**WALBERTON PARISH COUNCIL
INCLUDING FONTWELL AND BINSTED**

Stoneybrook Farm, Eastergate Lane – WA/61/19/PD - Objection

Walberton Parish Council objects to this application.

Drawing 4 - Illustrative
Proposed Part Ground Floor Plan

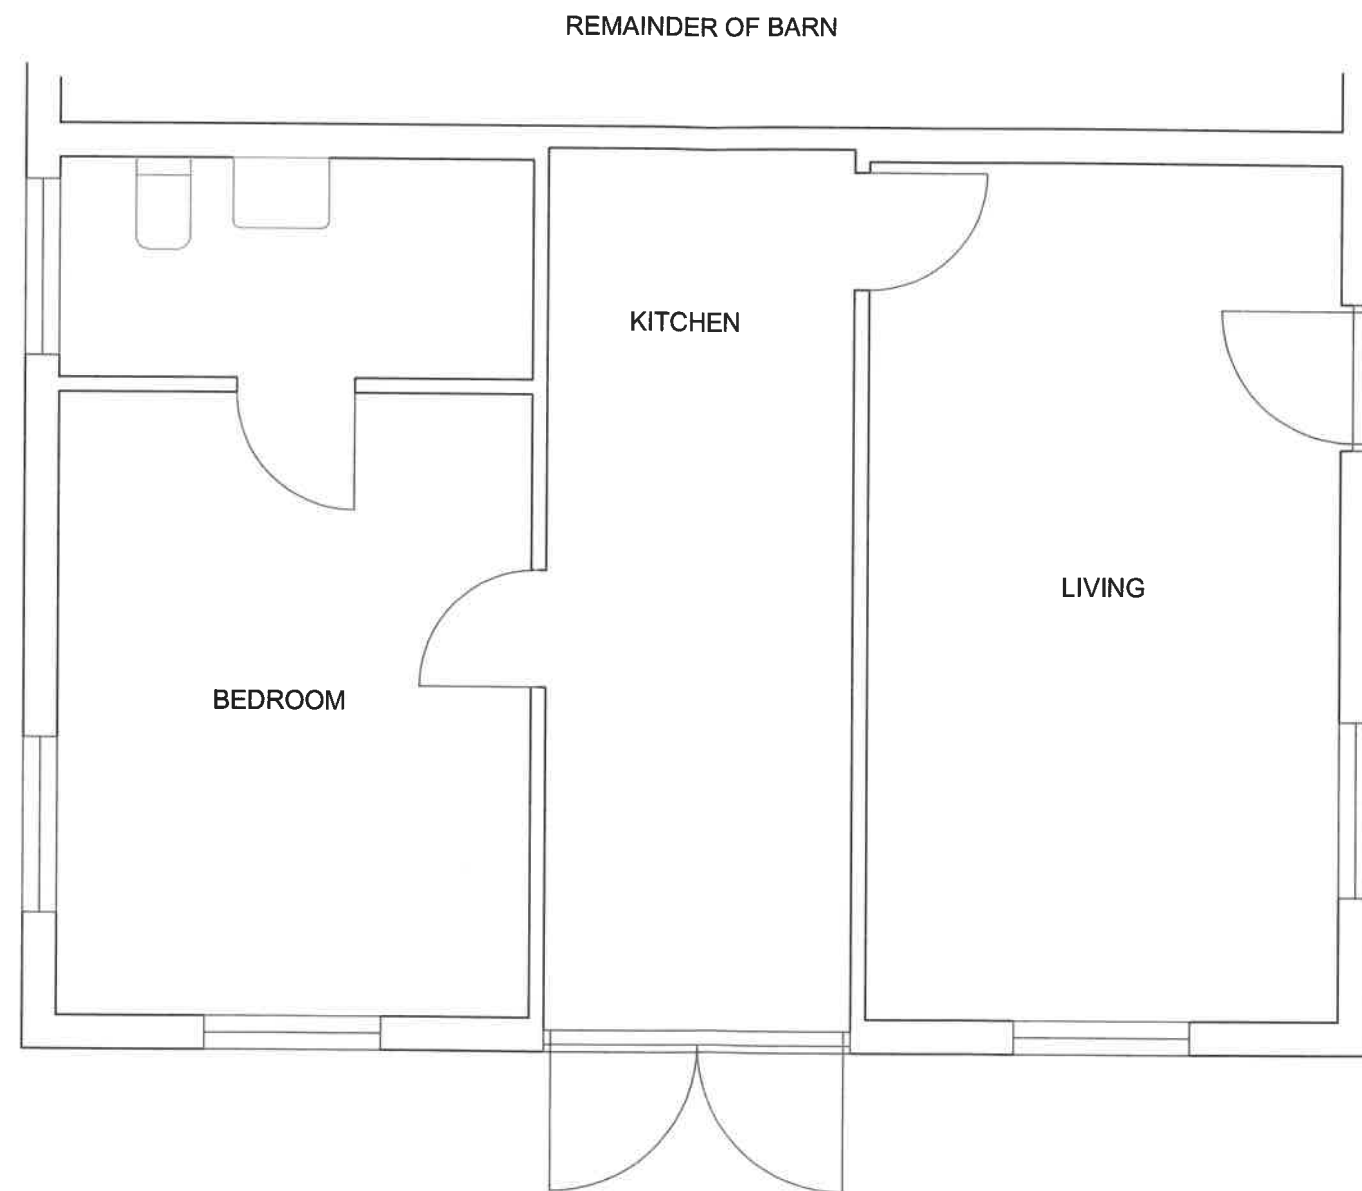
- The submitted plan currently does not appear to be valid as the building to be modified does not appear in the documentation available to be indicated. Normally, an outline in red is expected to demonstrate the area under consideration and its location in the site.
- The existing layout refers to first floor, but the proposed layout is ground floor which do not tally with the application.
- Planning for a dwelling has been previously refused on several occasions. The successful application, on appeal, was for siting a mobile home on site with the condition that occupation is limited to a person solely or mainly employed or last employed in the locality in agriculture and their dependents. There is currently no evidence of a mobile home, caravan or other type of moveable home on the site despite it being the address of four registered voters.

Walberton Parish Council requests that Arun District Council conducts a site visit to satisfy themselves of the correct position i.e. first or ground floor and that no building on the site is currently being used as a residence. We cannot find any permission, other than that for the mobile home, for residential use.
